**OS Parcel 5700 South West Of Grange Farm,  
Street Through Little Chesterton, Chesterton**

**23/02810/NMA**

**Proposal:** Amendments to the wording of condition 2 (proposed as non-material amendment to 22/01144/F)

Drawing Name:	Enlarged Welfare Core
Drawing Stage:	CONSTRUCTION
Status:	53
SGP File Ref:	000002
SGP Project No.:	13-222
Date:	06/09/22
Drawn:	YJM
Checked:	MMS
Scale:	1:50
Rev:	P01
Drawing Number:	13-222-SGP-01-ZZ-DR-A-201153
Project Code:	Originator
Volume Label:	Type
Size:	Number

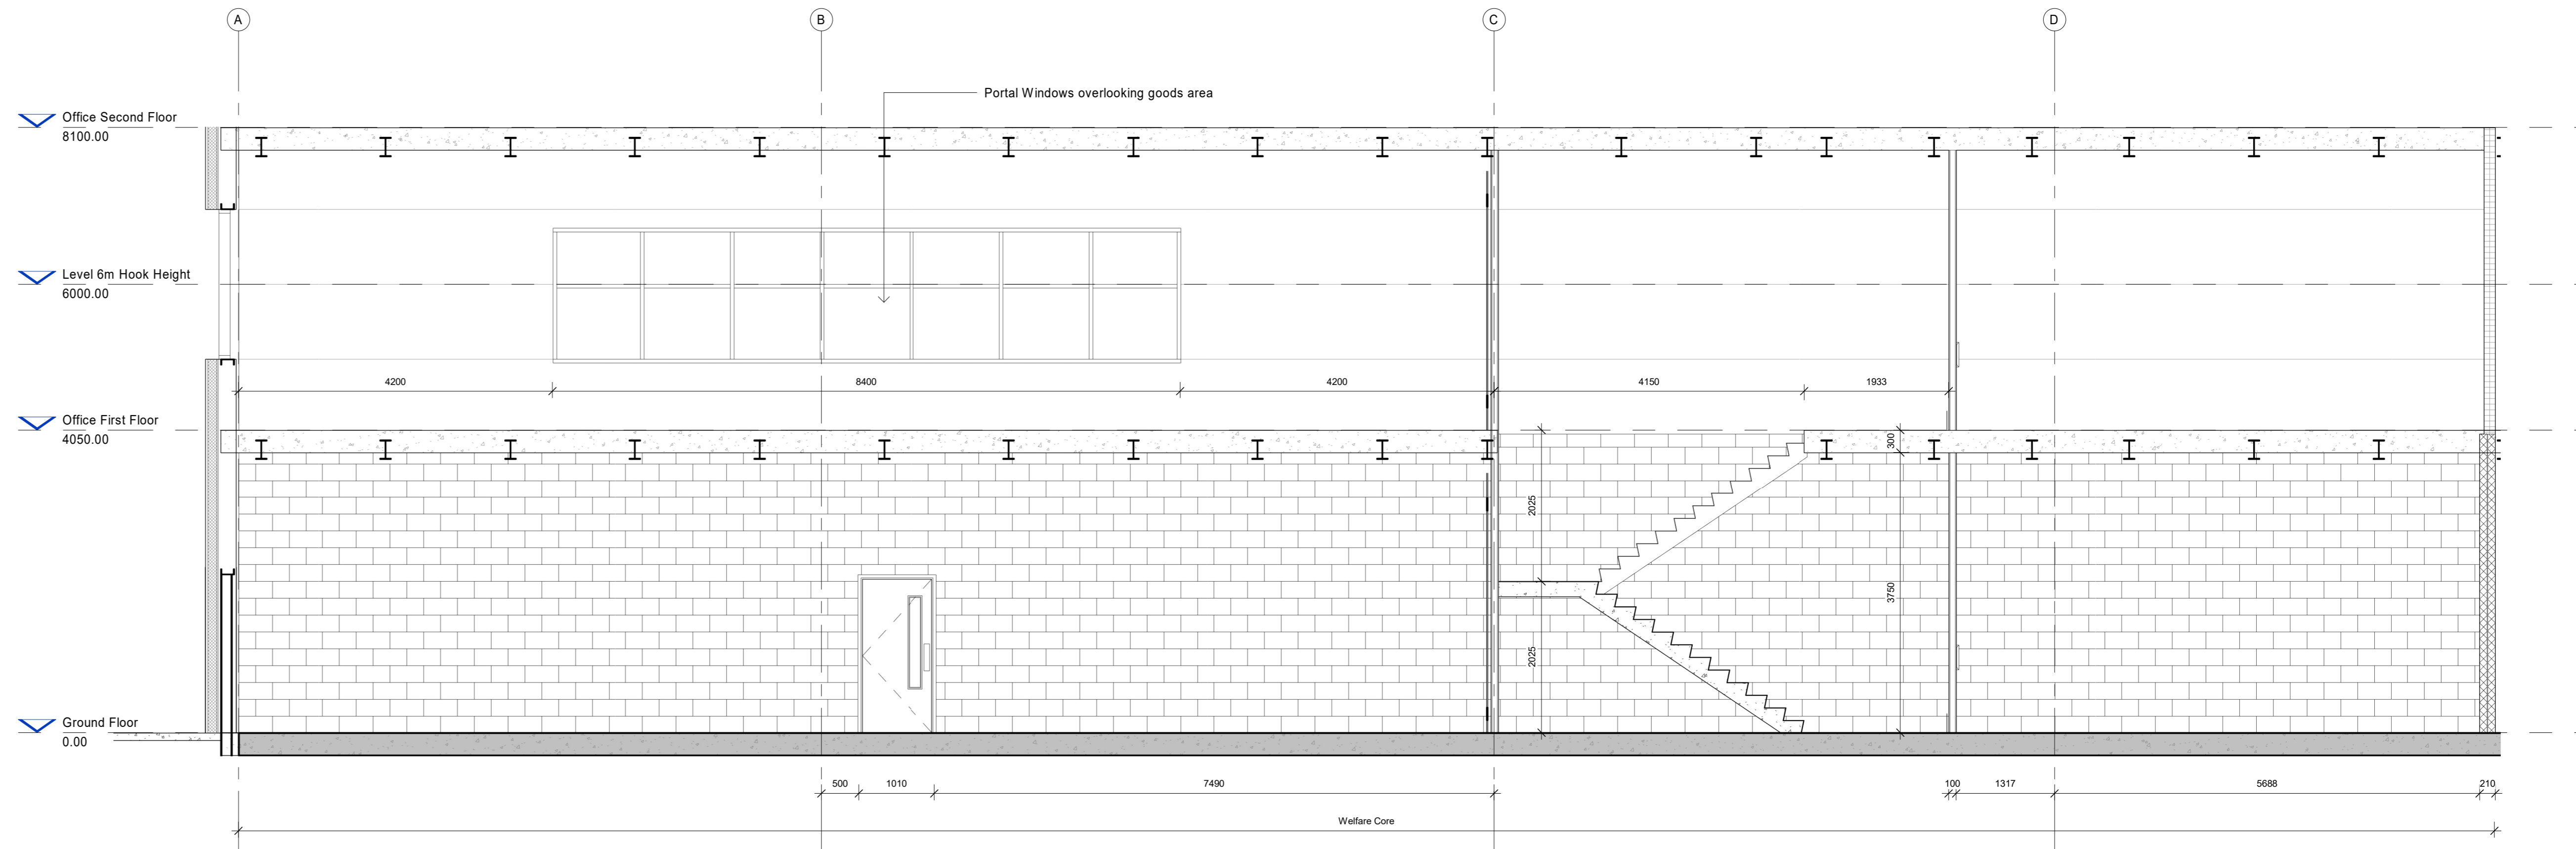
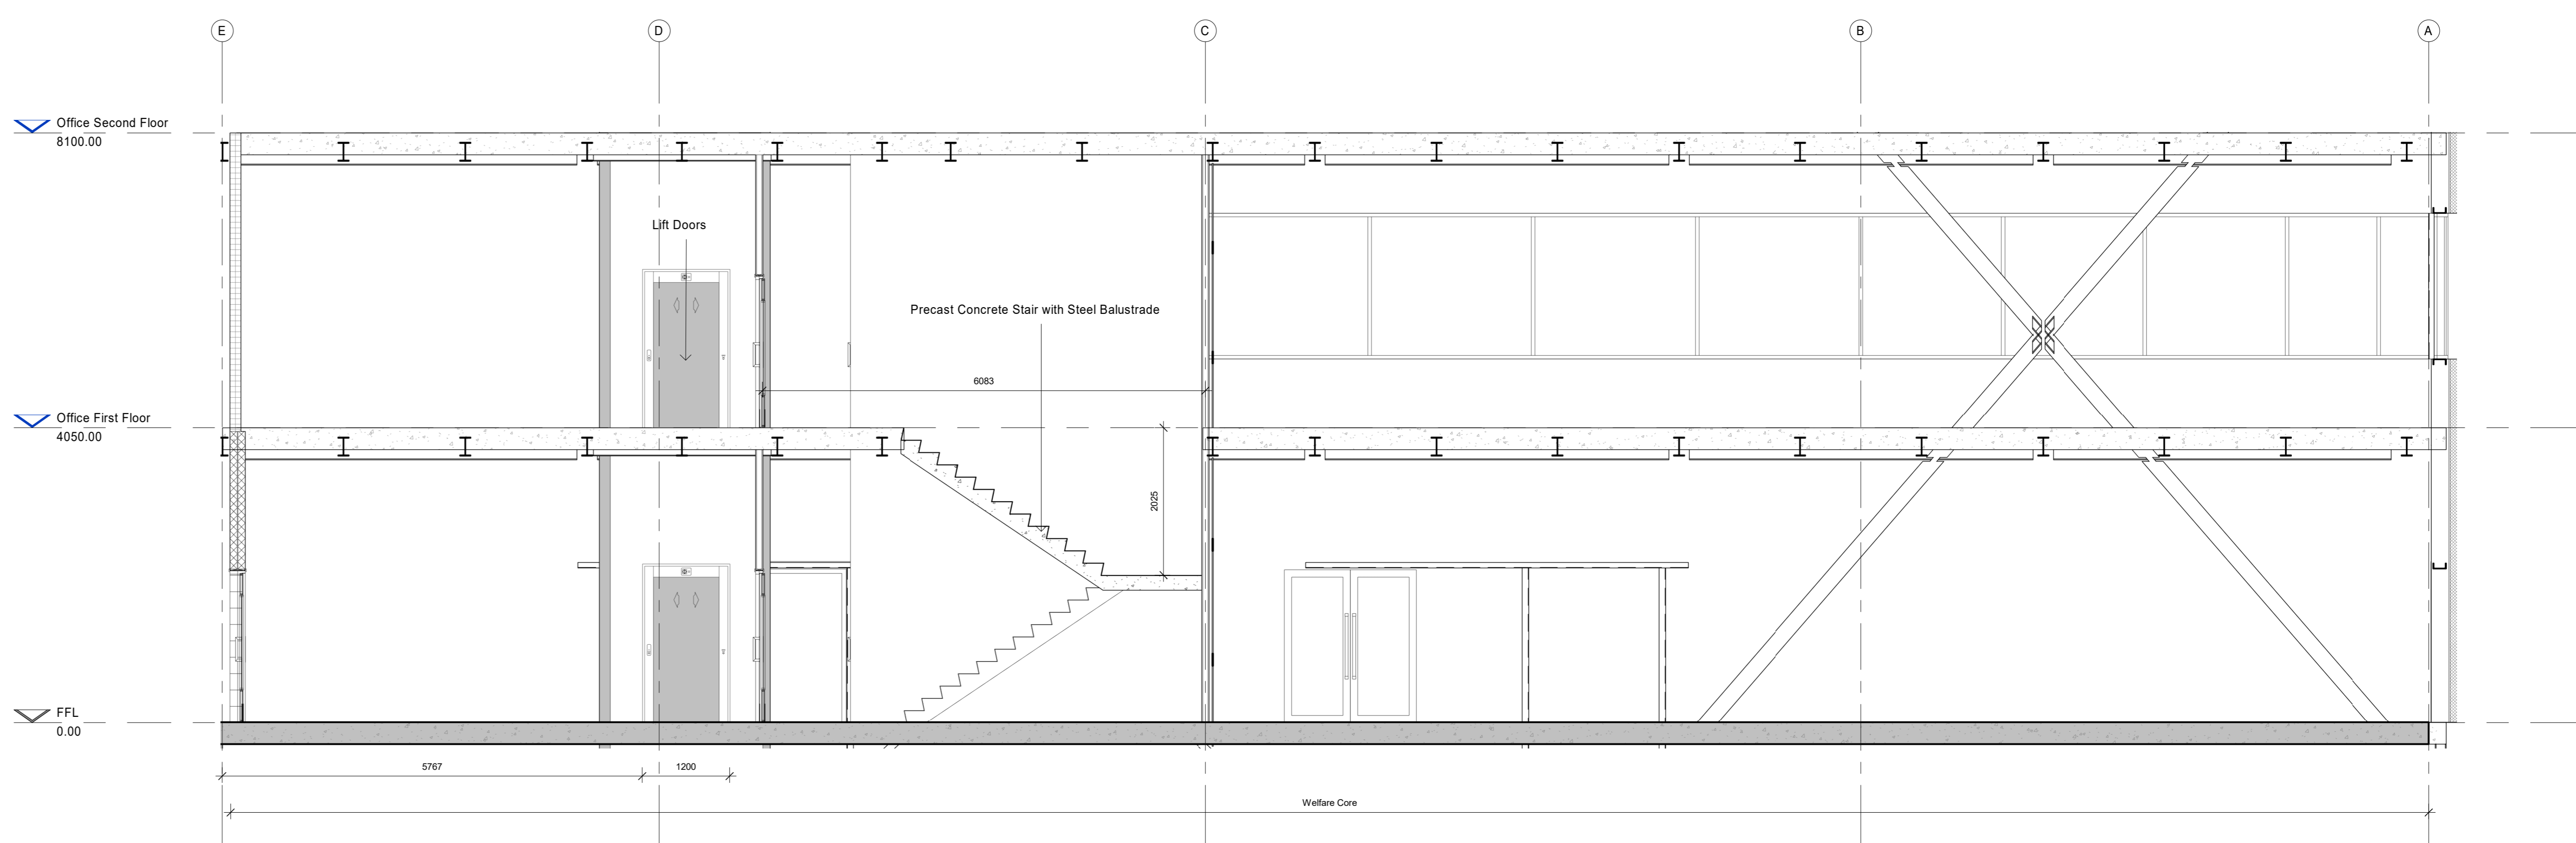
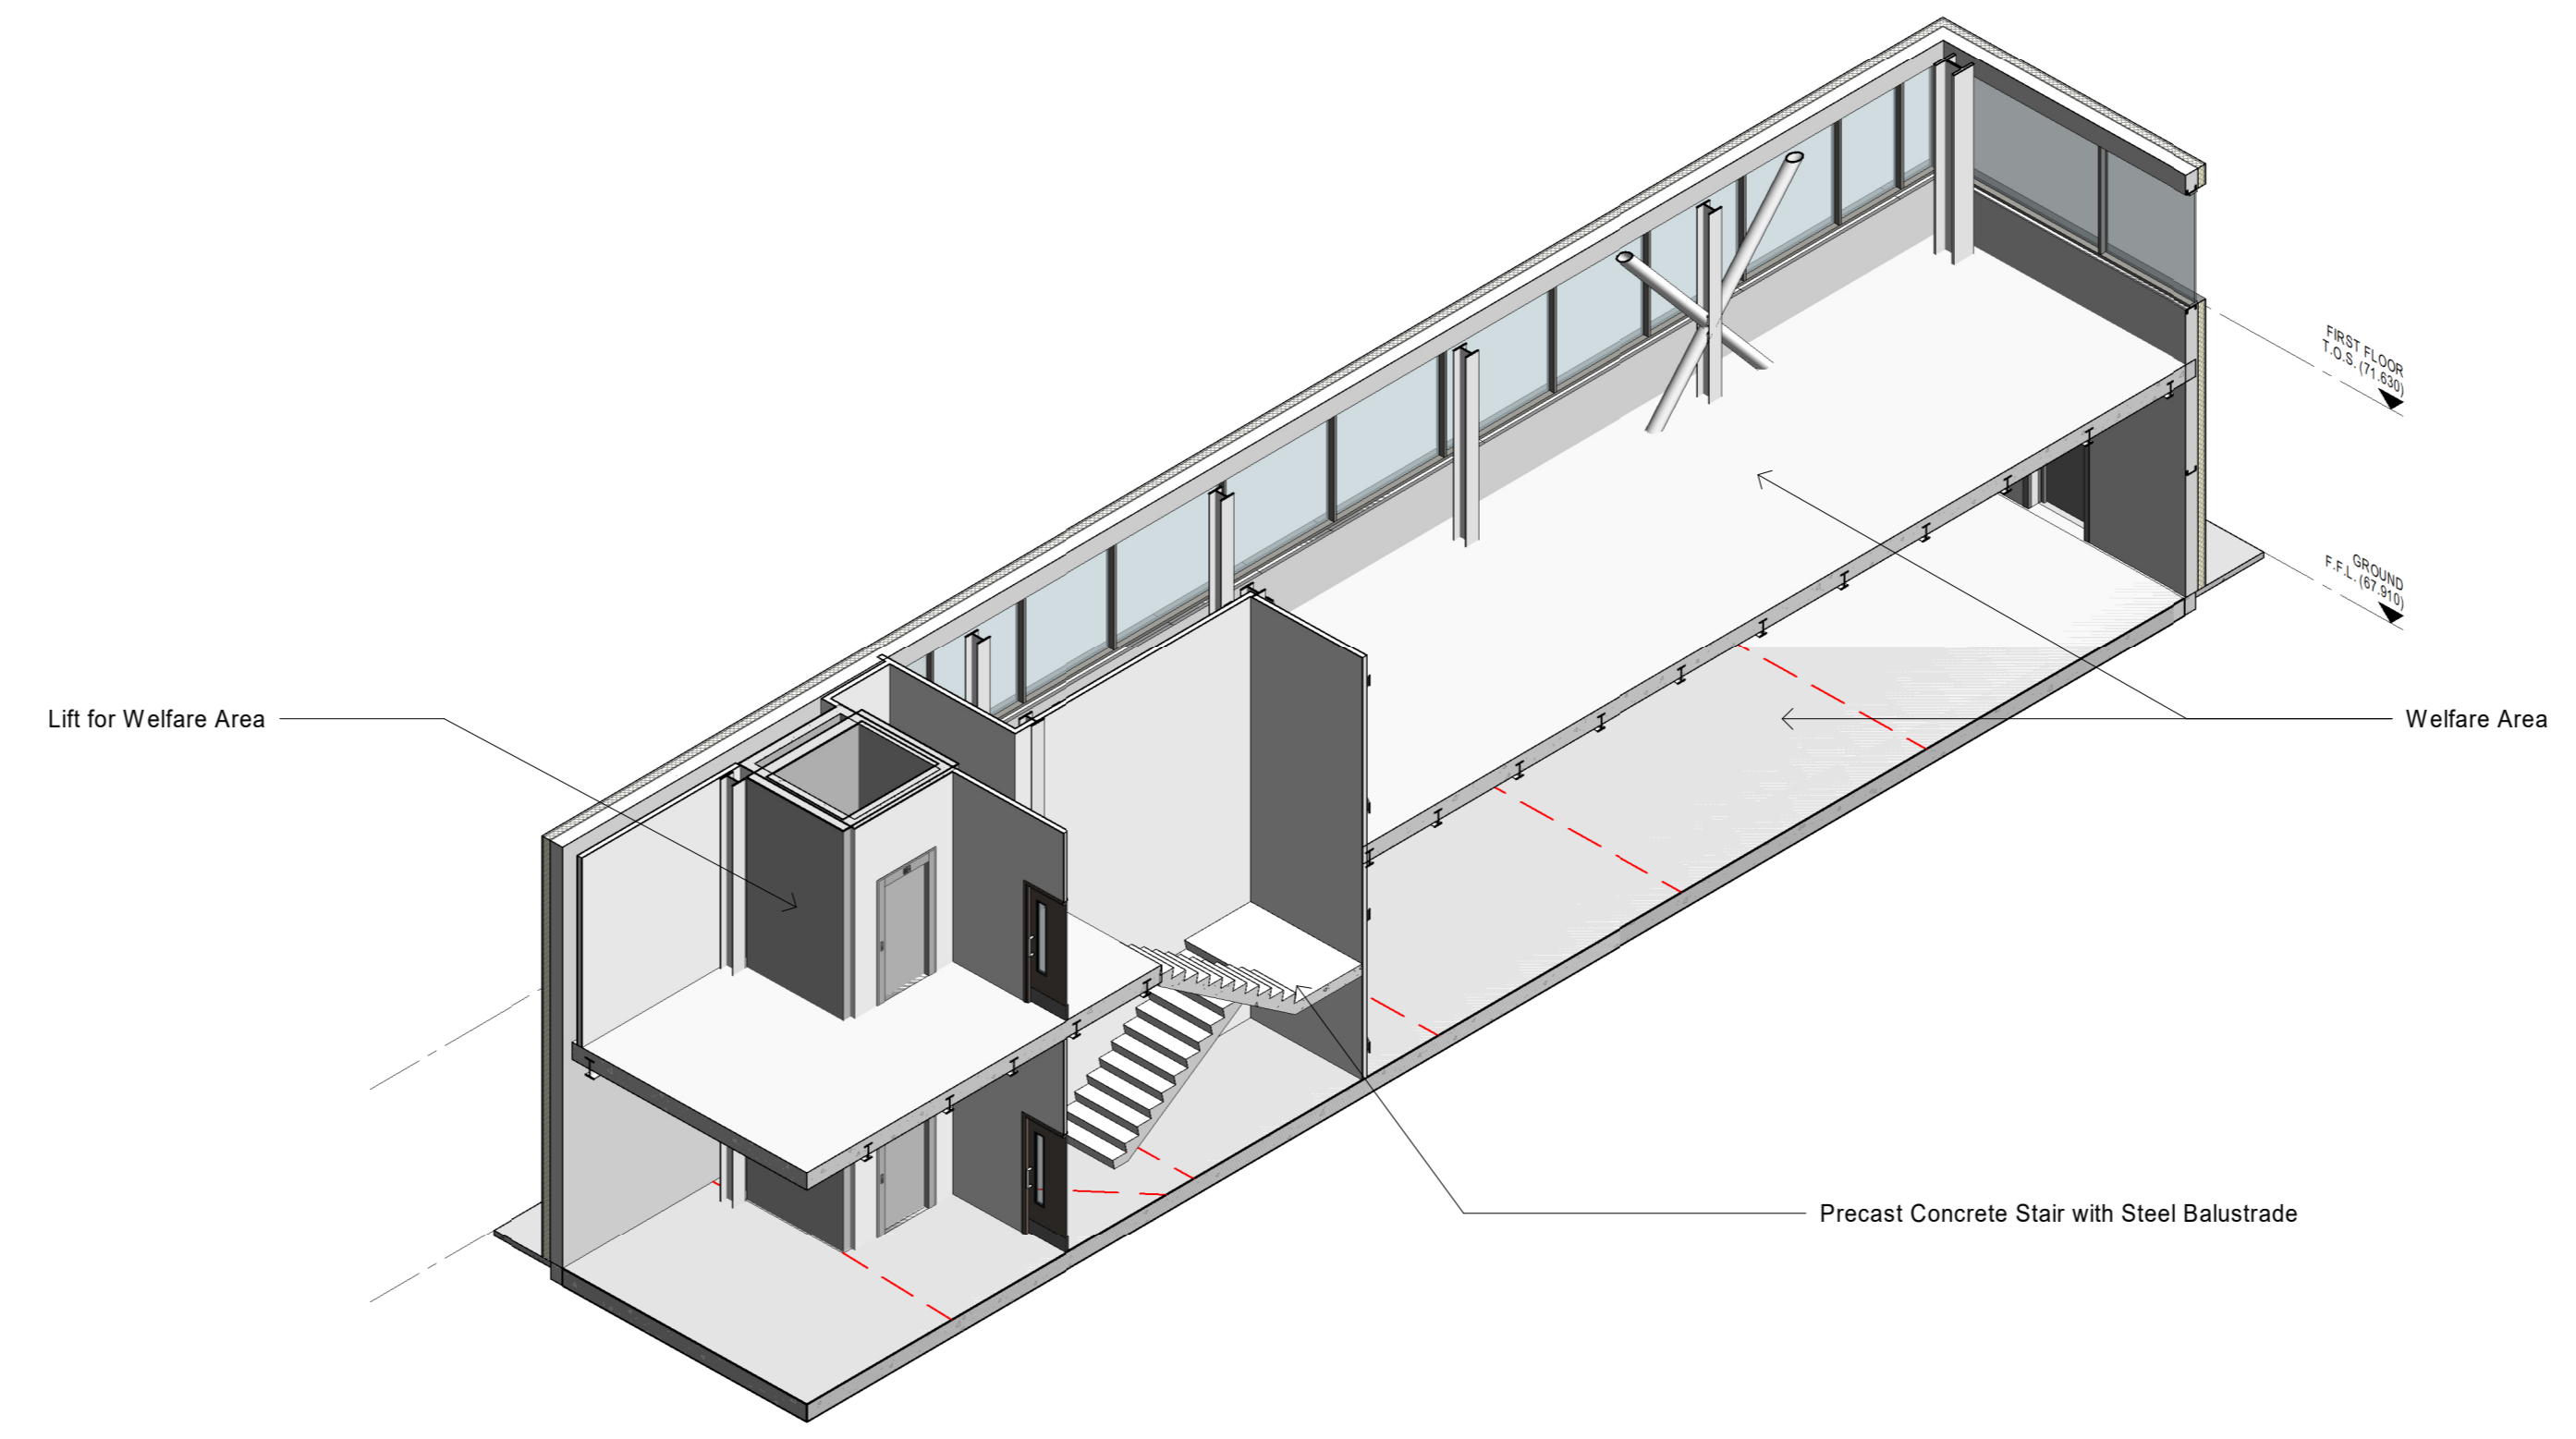
- Internal alterations within the production hall to construct a two-storey welfare block with lift to replace the approved external Facilities Management Building. There would be no increase in the overall floor area and the proposed changes will be internal to the main production facility building.

- 5.4. The incorporation of a Welfare Block within the main building to allow the approved freestanding Facilities Management Building to be removed from the scheme, which would reduce the number of buildings on the site. The changes to the elevations, particularly when appraised in the context of the overall scale of this large commercial building, are all considered to be negligible and would not, even cumulatively, significantly or detrimentally affect the character and appearance of the approved building or the wider area.
